One Joy Place

Posted in group: **Planning Board**

Hello. I'm a resident (and property owner) at 119 Brackett St., Apt. 1F, and I would like my comments considered at tonight's Planning Board hearing regarding One Joy.

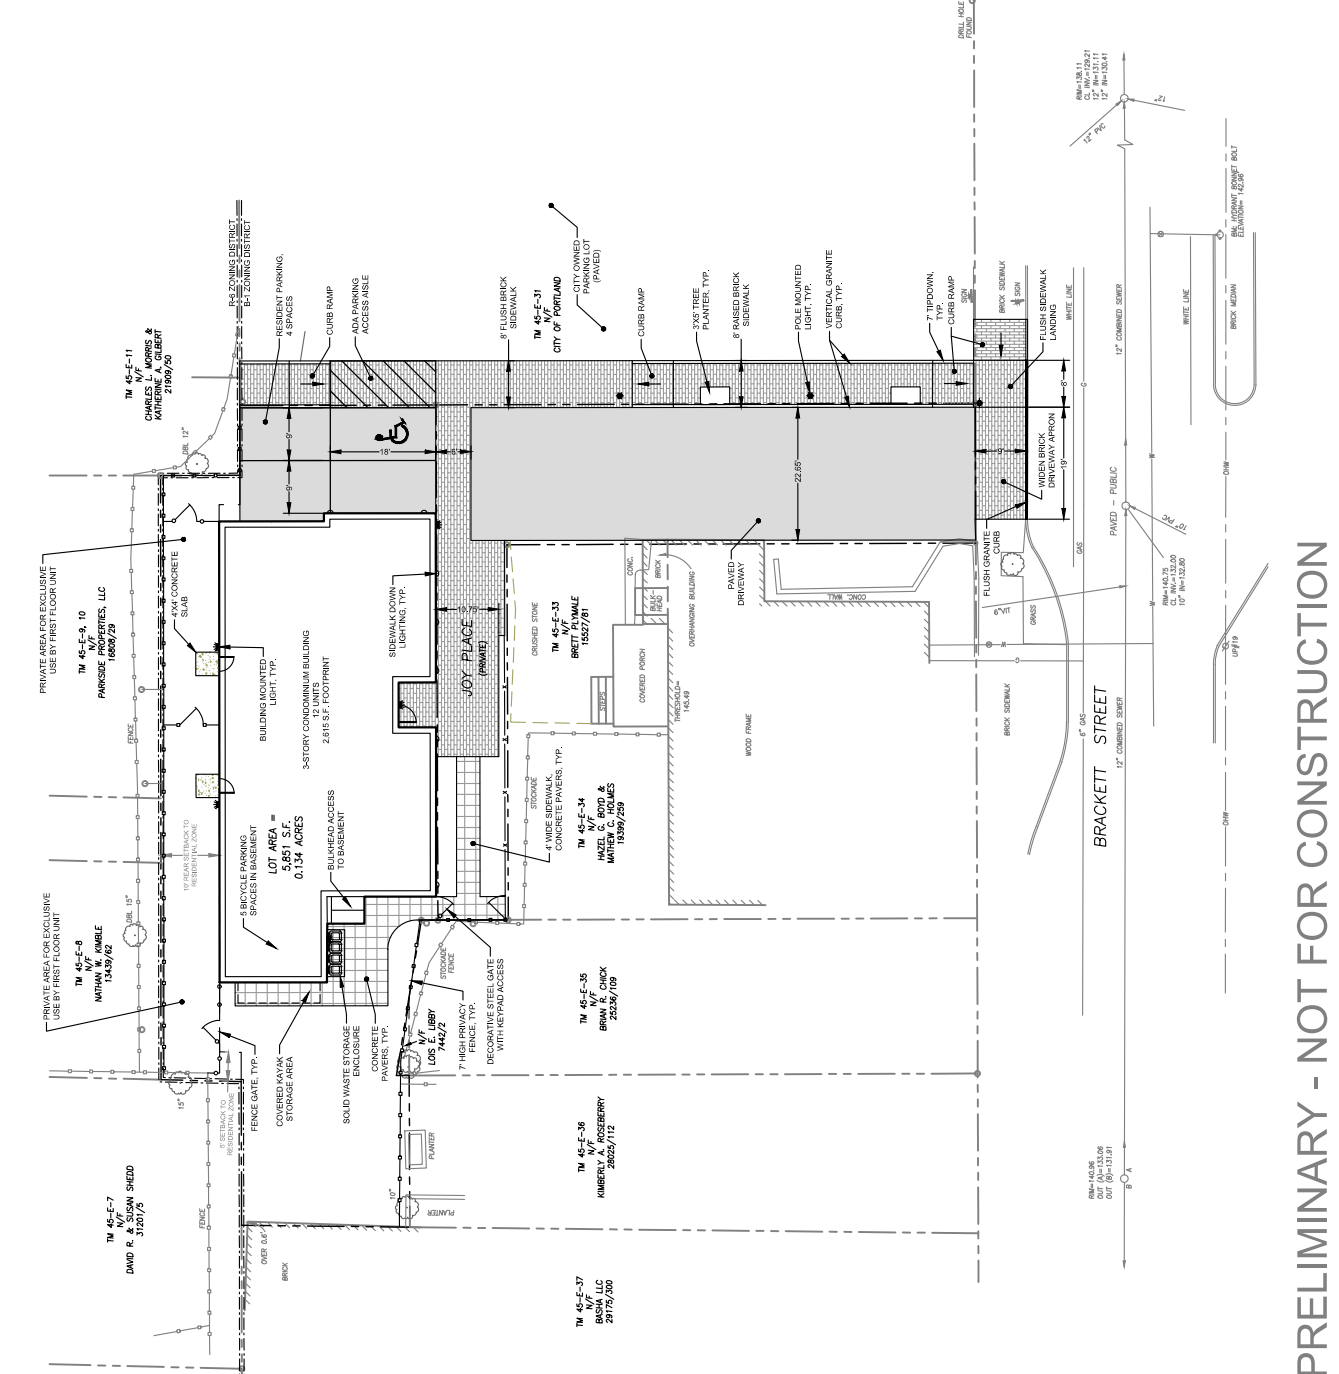
My big concern, however, is parking. The project only offers 3 parking spaces for residents (though only 2 leases - one of which is for two spaces)--meaning the other ten units must rely on street parking. As I hope you already know, street parking is at a premium on Brackett Street and in the heart of the West End in general. I work at home, and rarely have trouble finding a space for my car during the day. But overnight parking is challenging if you get back to the neighborhood after 6 or 7 pm.

On their promotional website, the developers mention the lot next door, by Fresh Approach, as an option for residents of One Joy. "Most nights," they say, "you'll find a number of open parking spots." I walk my dogs down Brackett Street most nights, and I definitely don't see open parking spots in that lot.

Parking in the West End is going to continue to be a critical issue as more lots are condo-ized. Please require the developers of One Joy to offer more parking in order to minimize their contribution to this problem.
